From: Nolan, Chris <Chris.Nolan@lancashire.gov.uk>
Sent: 12 May 2017 11:40
To: Stephen Kilmartin; planning
Cc: LHS Customer Service
Subject: D3.2017.0319 - Waddington Arms, Clitheroe Road, Waddington

Site / Roof Plan

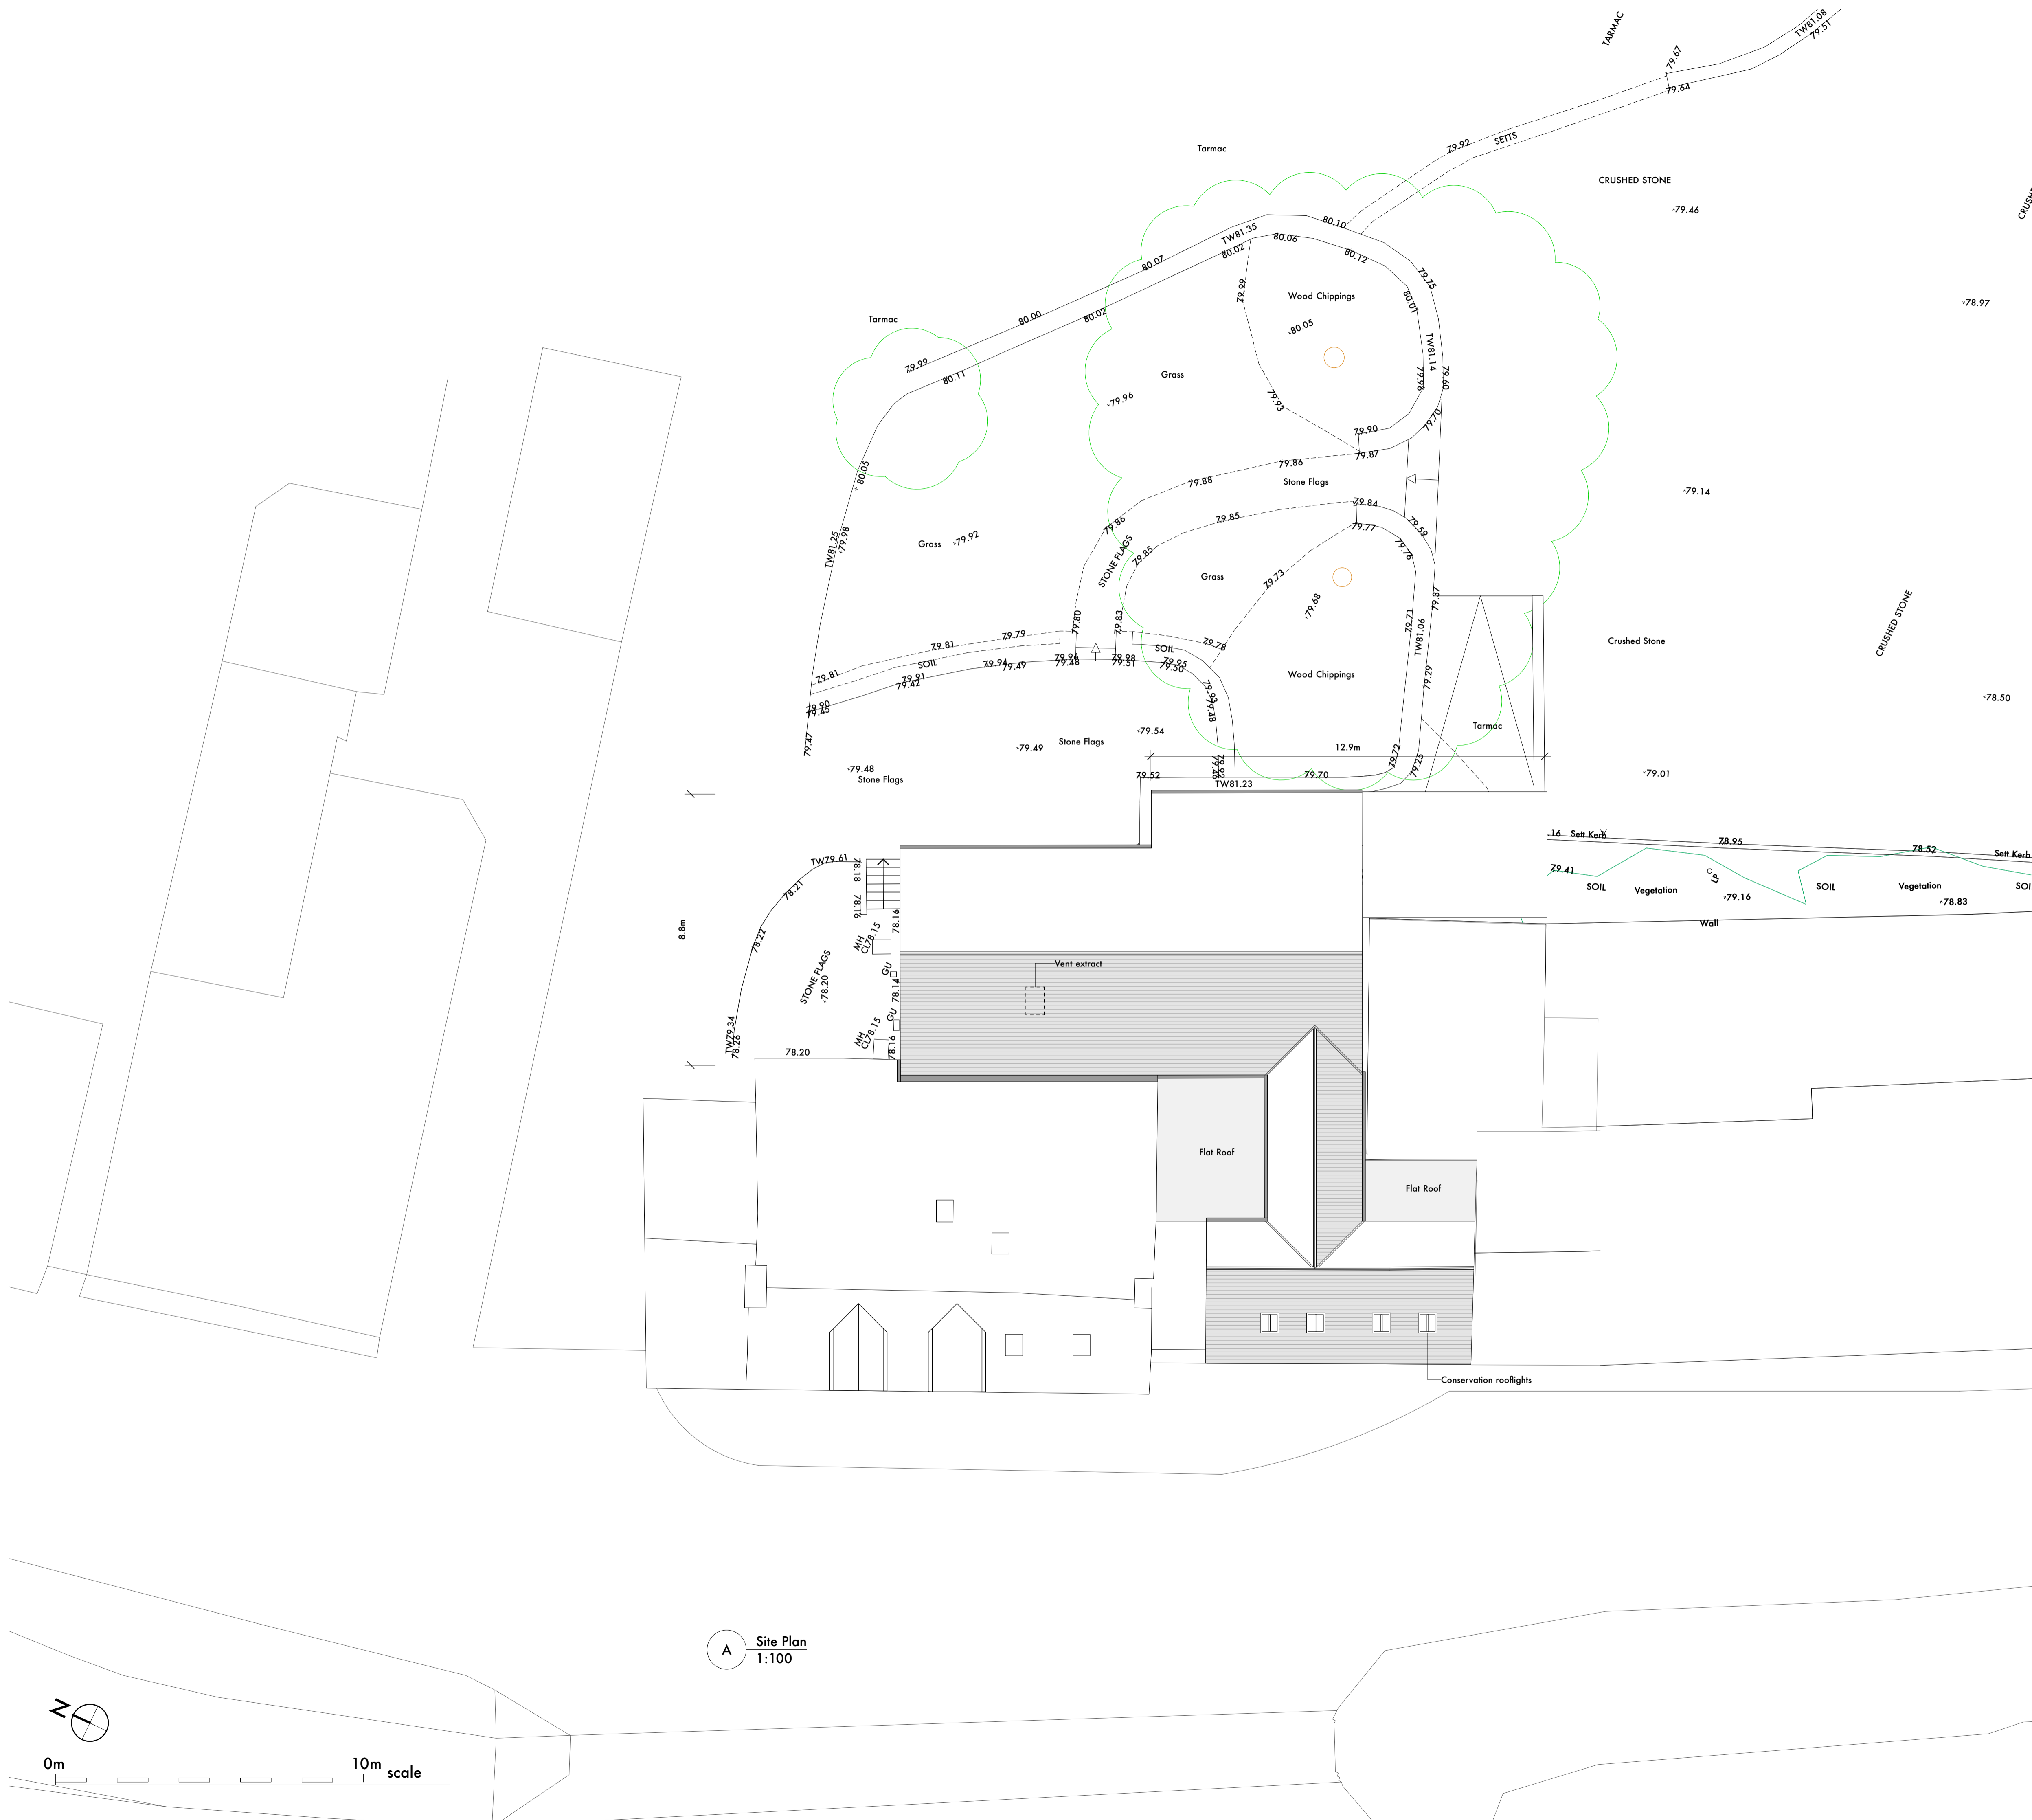
With regard to the above planning application. Whereas I am mindful to offer no objections on highway grounds we are concerned that the extra 8 hotel bedrooms will increase the occupancy of parking spaces in an area where car parking is reportedly difficult at peak times. I would like to see a parking survey for the site to indicate the levels of parking in the present car park at peak times. By peak times, for an establishment of this nature we would want the survey to cover Friday and Saturday evenings from 18:00 to 22:00 when it is considered to be the busiest times.

If such the survey indicates sufficient parking to accommodate any additional load by the additional 8 bedrooms then I would not raise issues on highway grounds. Should the survey indicate that the present provision is oversubscribed at peak times I would request that extra parking is provided for hotel residents and such provision is marked appropriately.
